HSE advice to Inspectorate / Applicant at EIA and S.42 stages

- (i) Letter dated 10 April 2019 to Planning Inspectorate at EIA stage
- (ii) Letter dated 15 October 2020 under s. 42 Statutory consultation

**PROPOSED Sunnica Energy Farm (the project)
PROPOSAL BY Sunnica Ltd (the applicant)
INFRASTRUCTURE PLANNING (ENVIRONMENTAL IMPACT ASSESSMENT) REGULATIONS 2009 (as amended) –
Regulations 10 and 11**

**Section 42 Planning Act 2008: Statutory Consultation
- Sunnica Energy Farm**

Drawing Title
**FIGURE 3-1
SUNNICA EAST
PARAMETER PLAN**

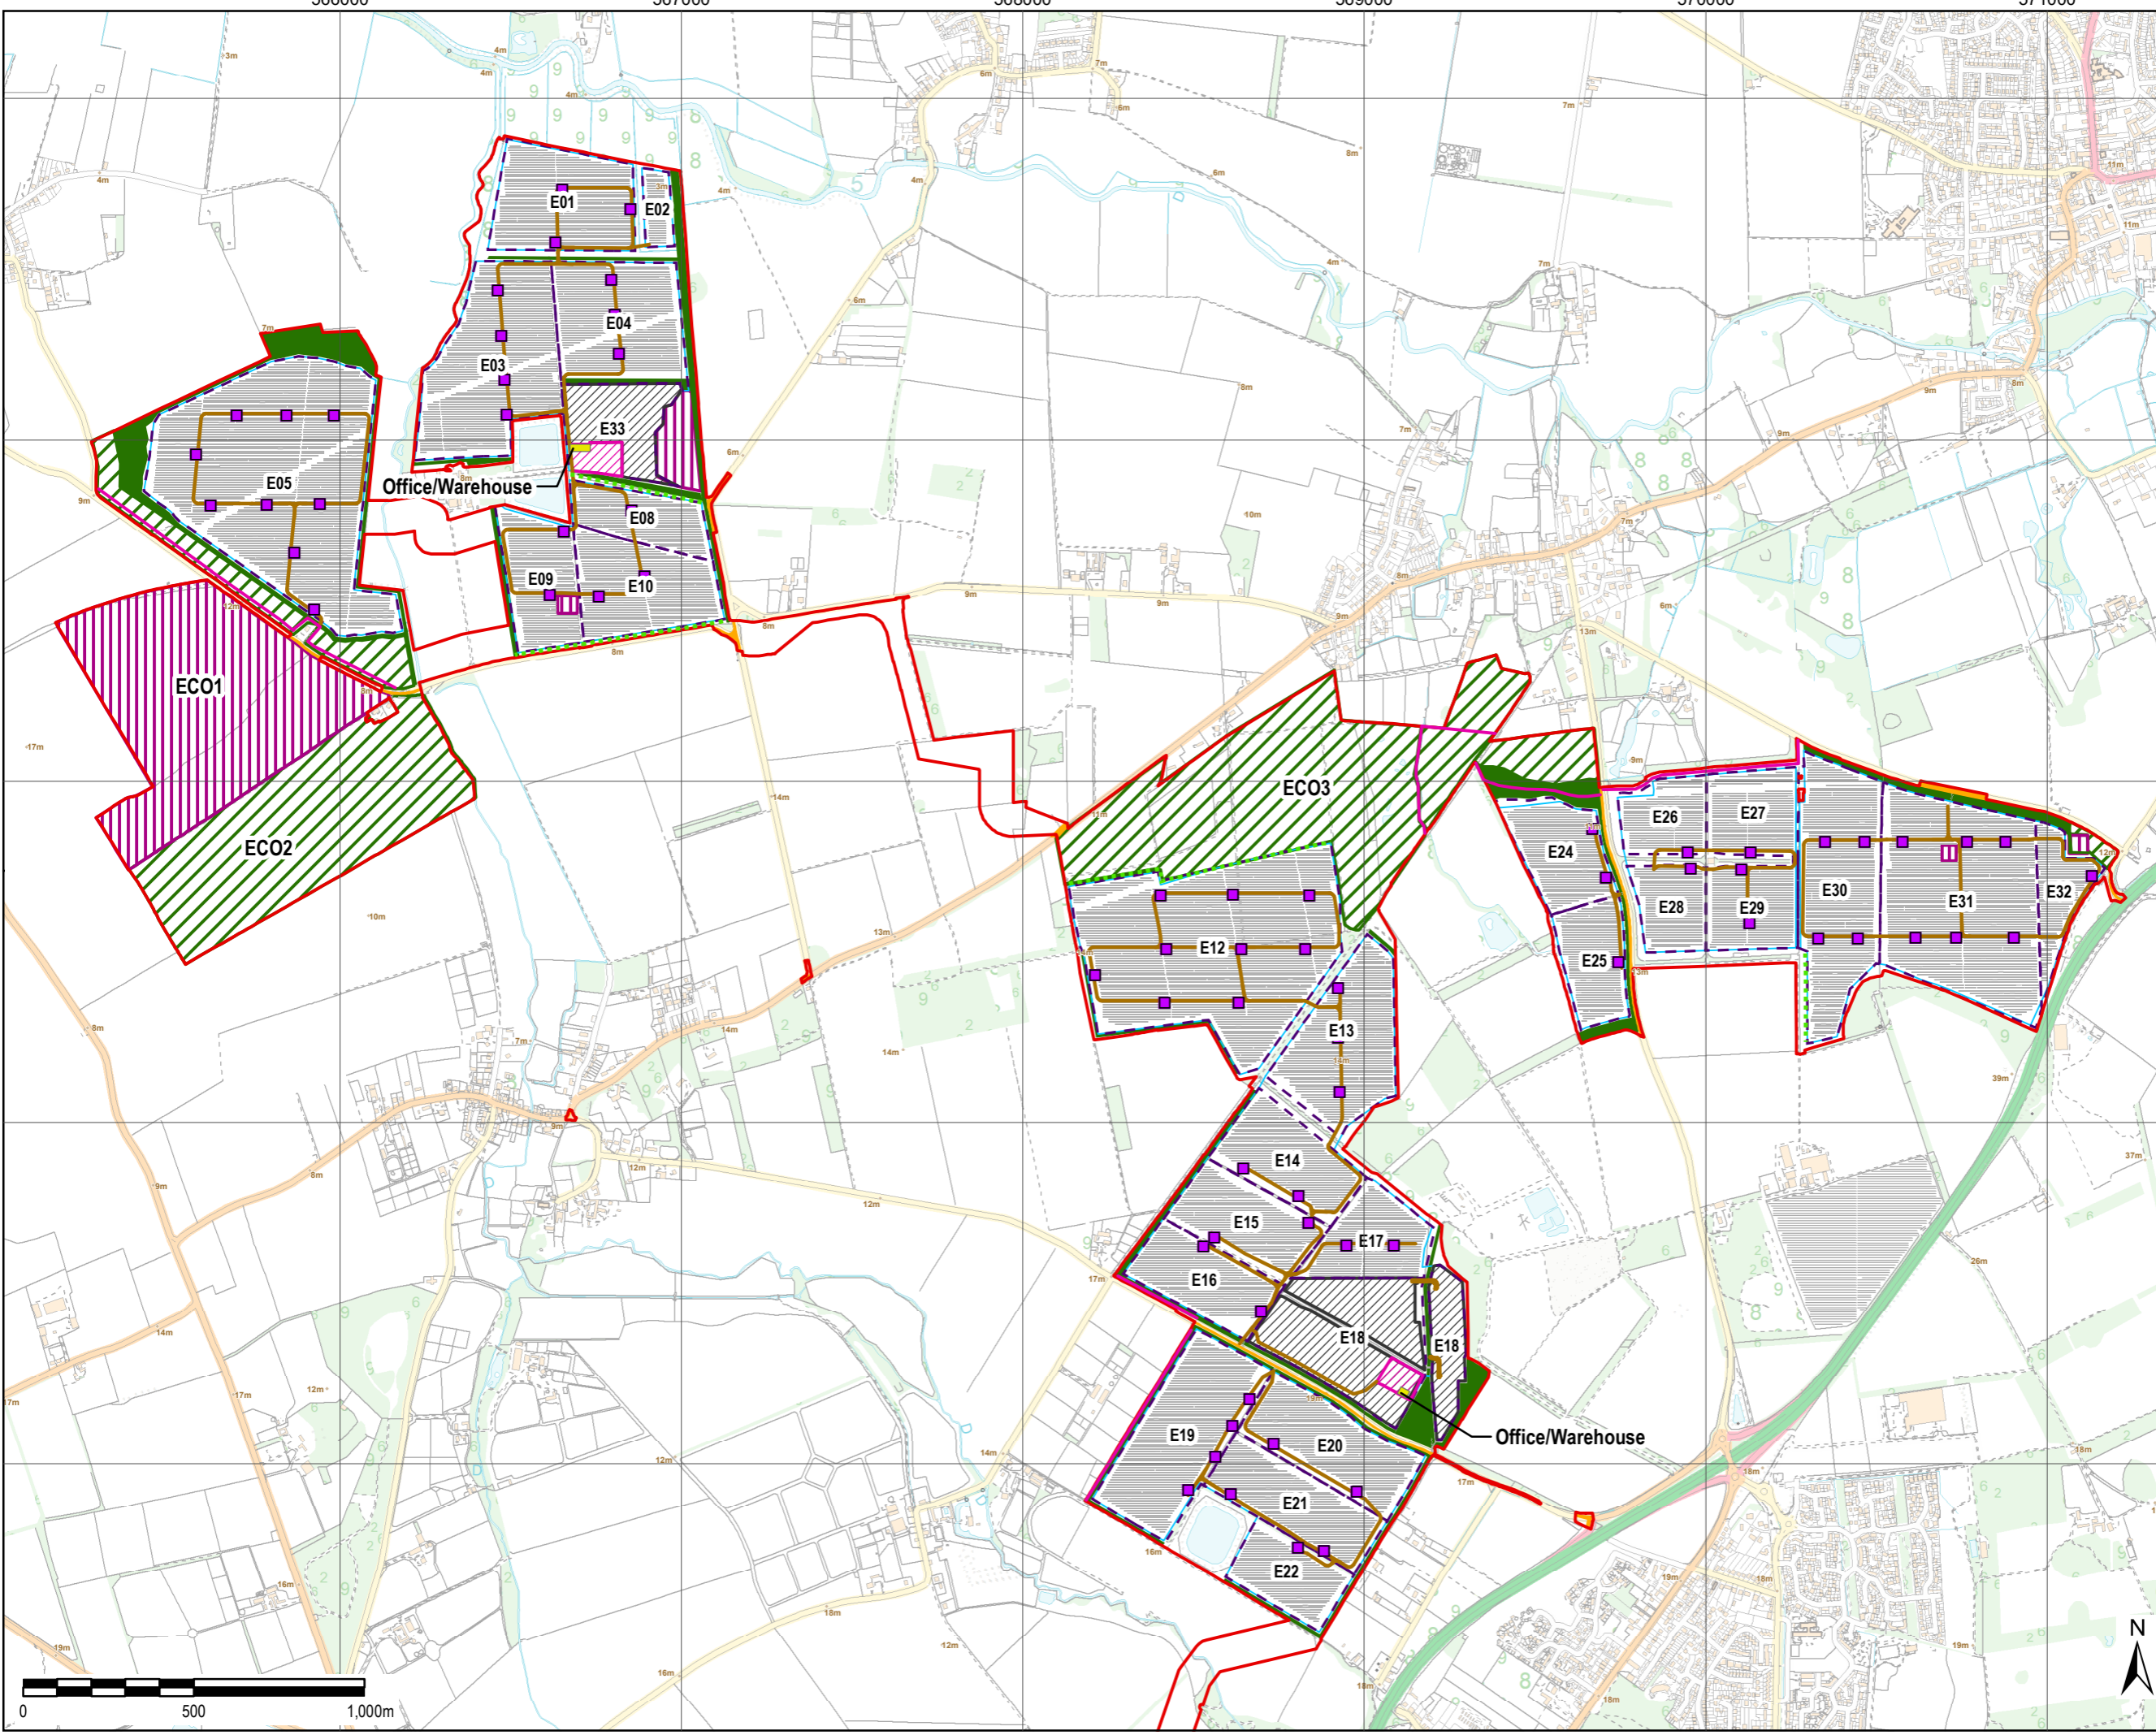
Both FIGURE 3-1 SUNNICA EAST SITE A AND B PARAMETER PLAN (drawing number 60589004_PEIR_SD_001) and FIGURE 3-2 SUNNICA WEST A AND B PARAMETER PLAN (drawing number 60589004_PEIR_SD_002) illustrate where populations may be present e.g. offices and warehouses. None of these are within any of the above zones; therefore, providing there are no major changes to the locations of populations HSE would not advise against this proposal.
